CM/51/21/DOC

Kents Farm House Brookpit Lane Climping BN17 5QU

Approval of details reserved by condition imposed under ref CM/27/21/PL relating to Condition Nos 2 - details of any new or replacement windows & doors and 3 - handrails & balusters.

Dwg. No.
112/168/11

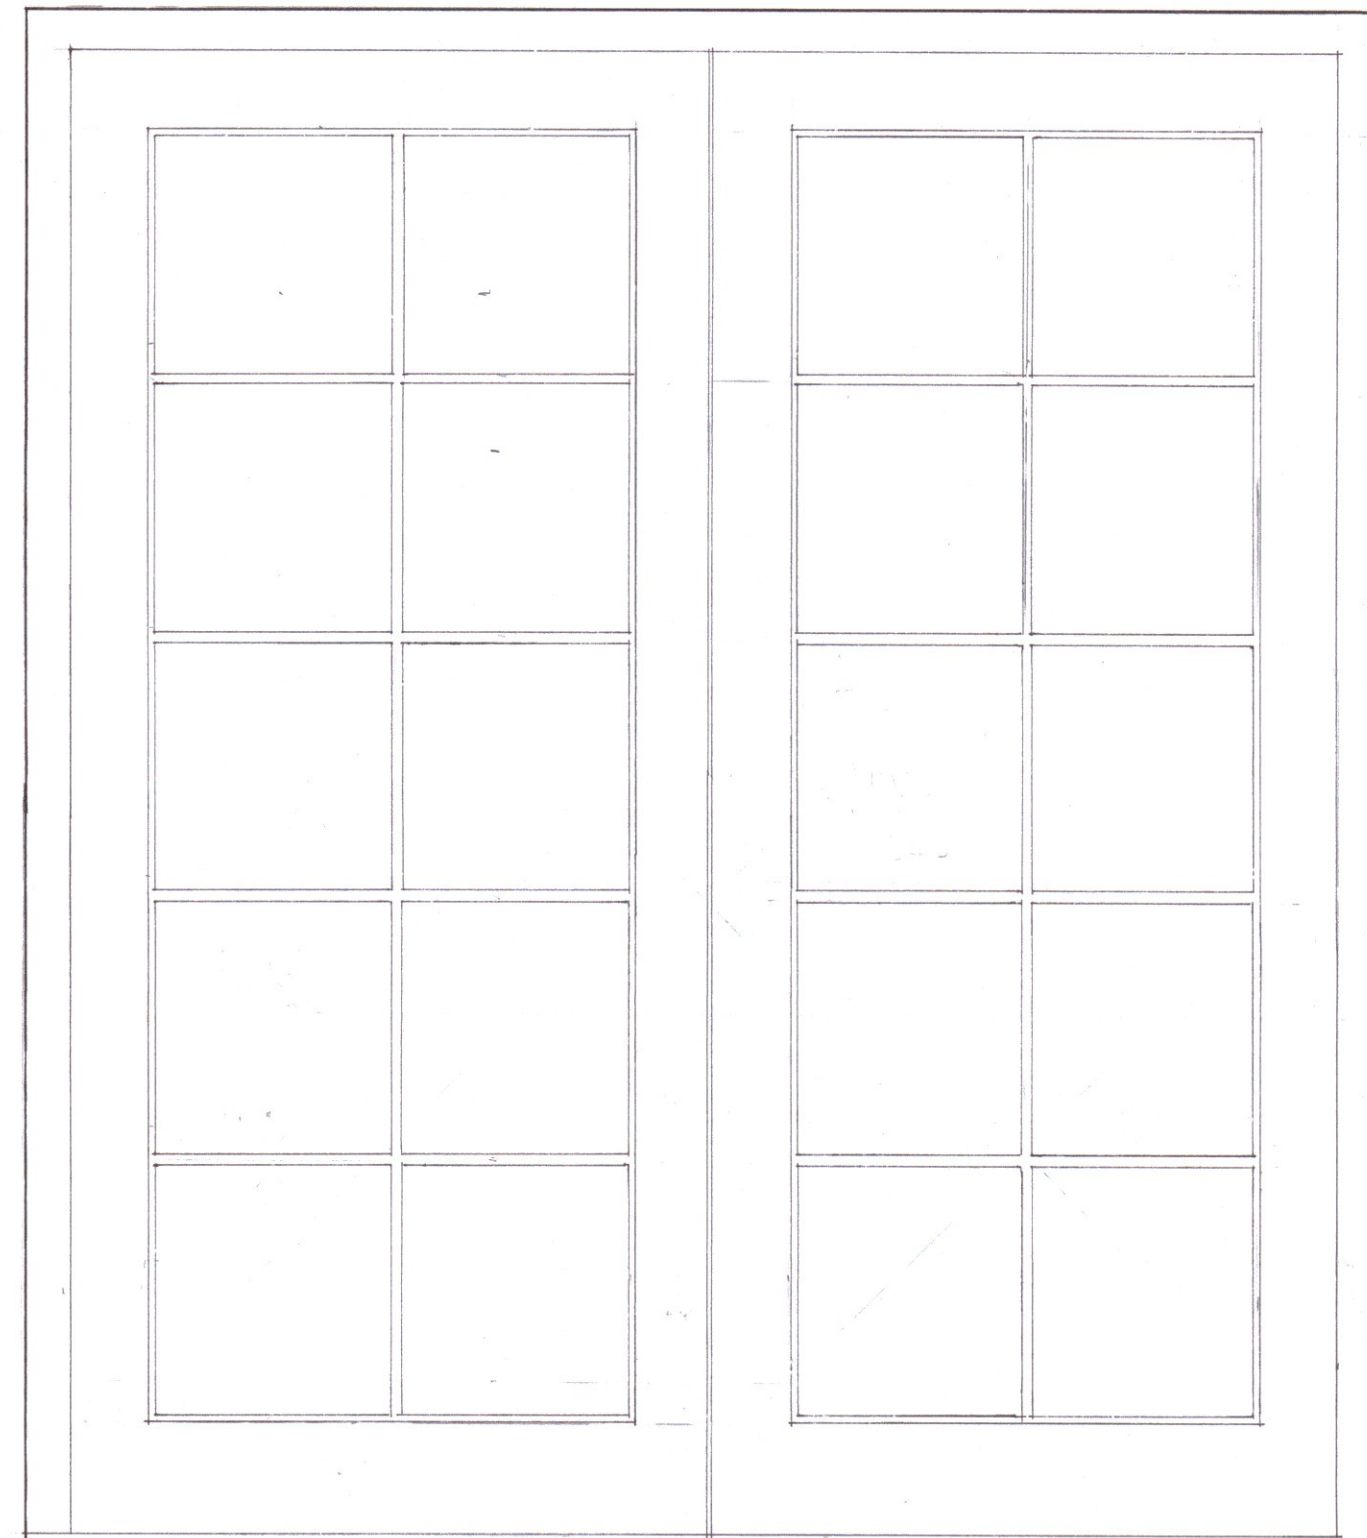
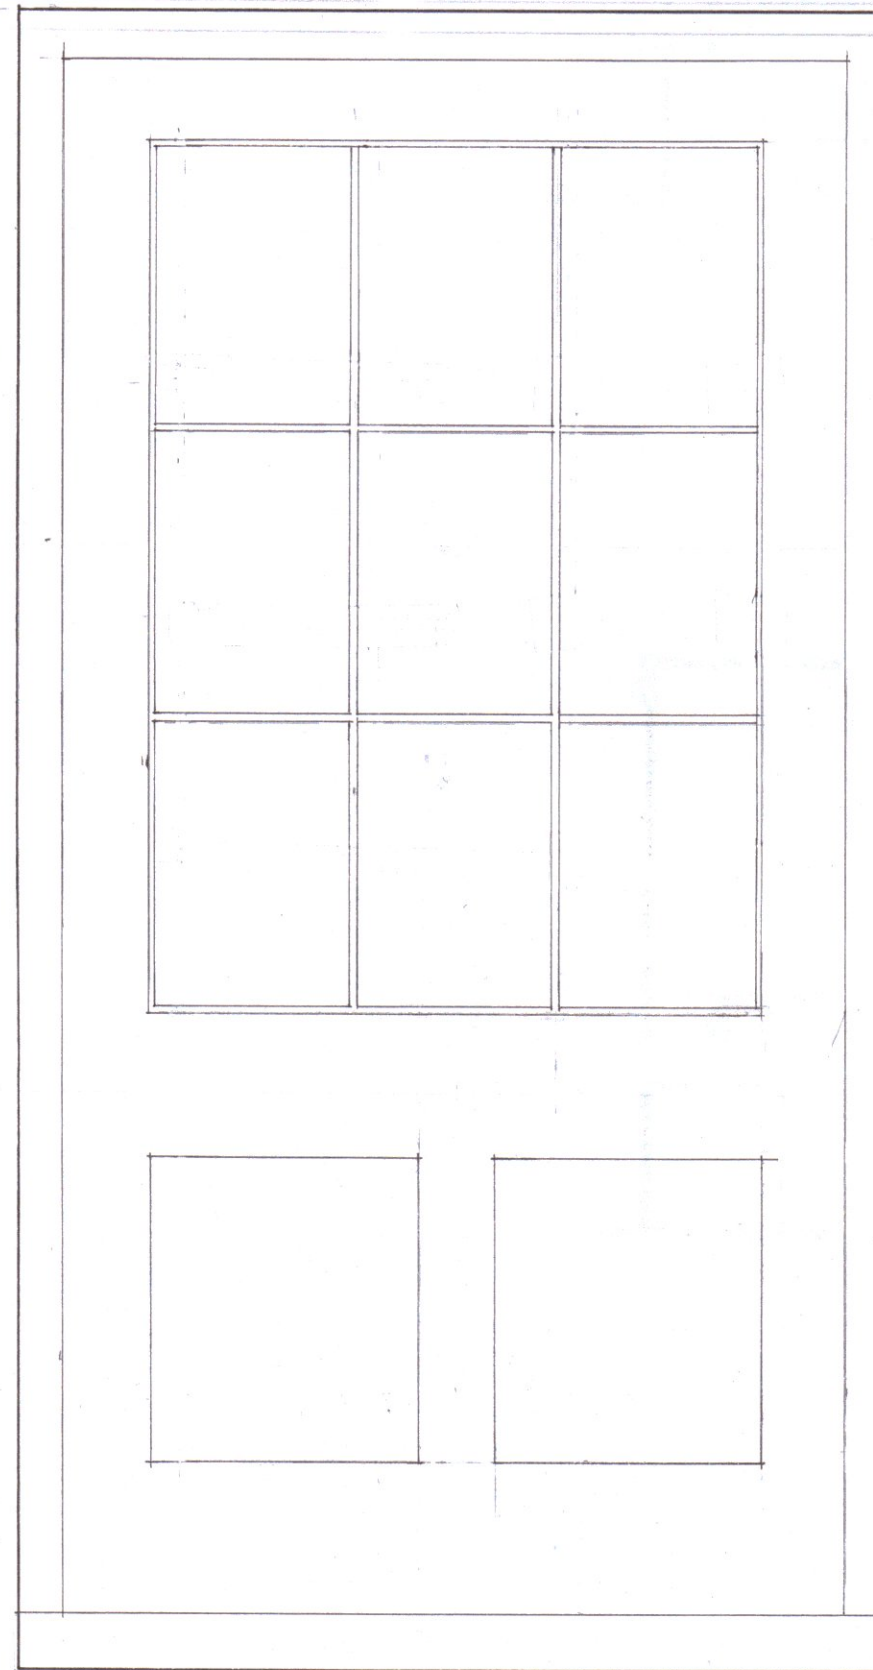
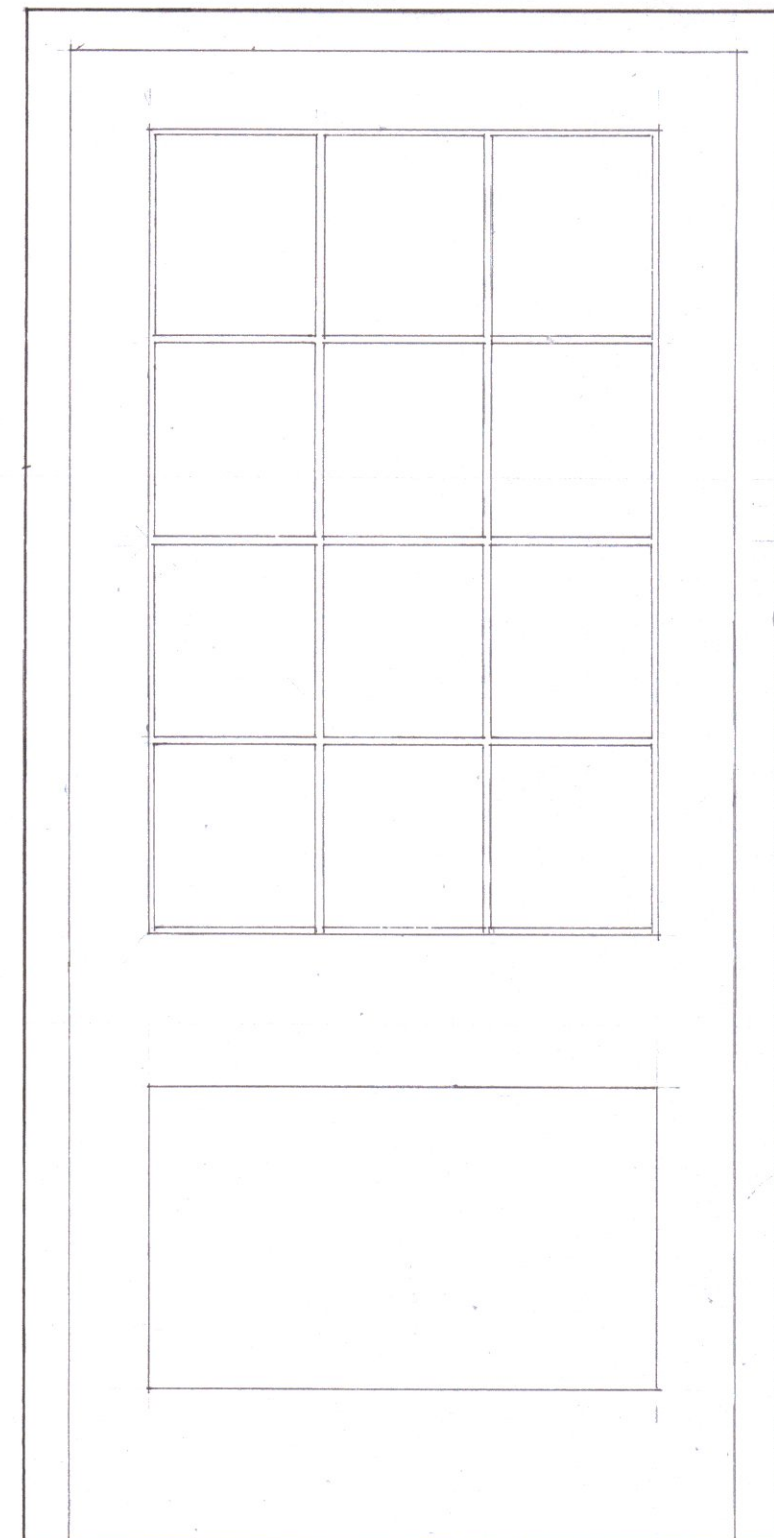
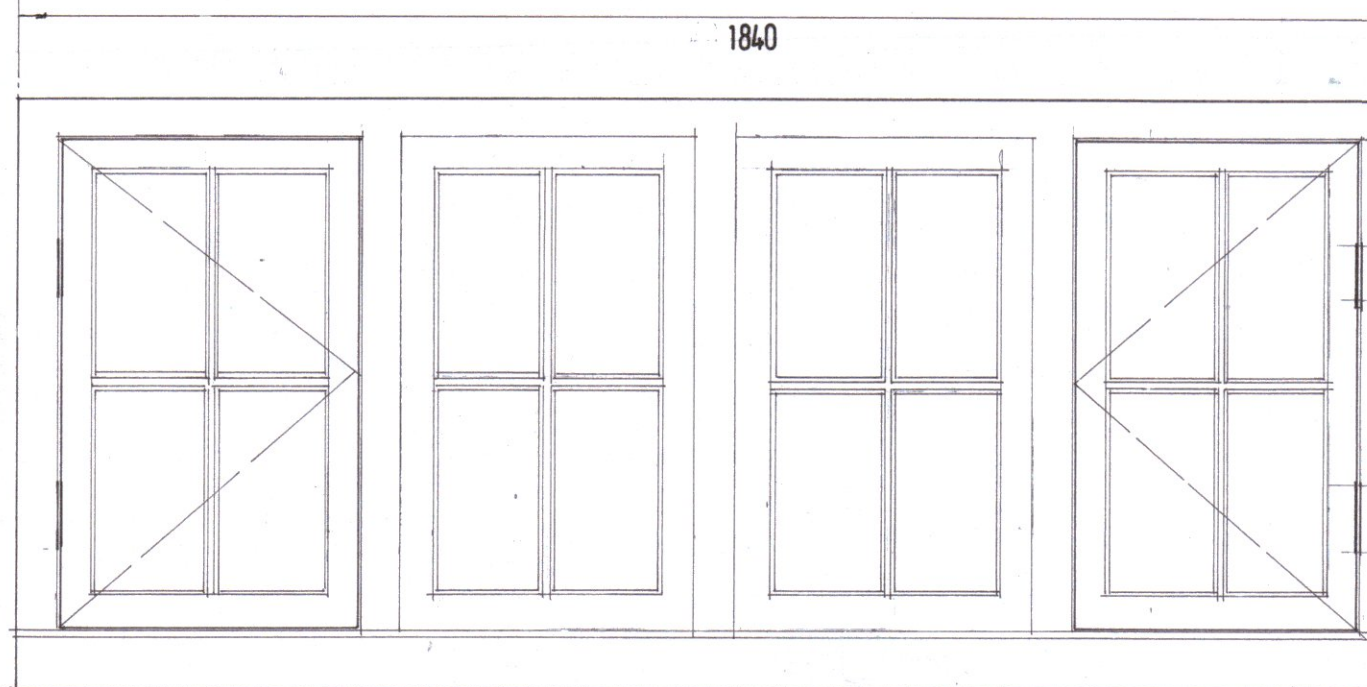
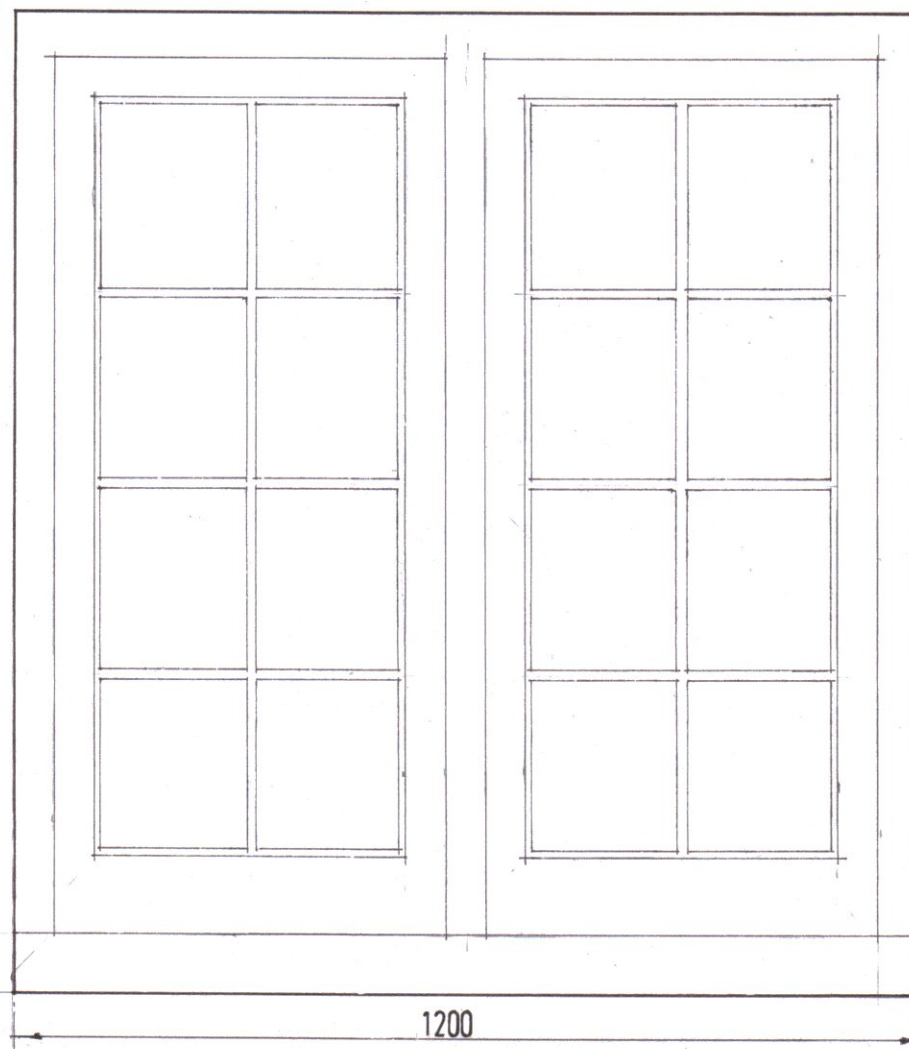
Condition 2: The schedule of materials and finishes indicates that the new windows and doors will be timber with hardwood cills and double (thin units - 12mm which consist of 4 x 4 x 4). However, the section of both the doors and windows provided as part of drawing 112/168/10 indicates that the glazing will be 24mm (a 'standard double glazed unit'). Please can the details of the double glazing be confirmed. I would not support the use of the larger/standard units. Also please can it be confirmed why applied glazing bars are proposed?
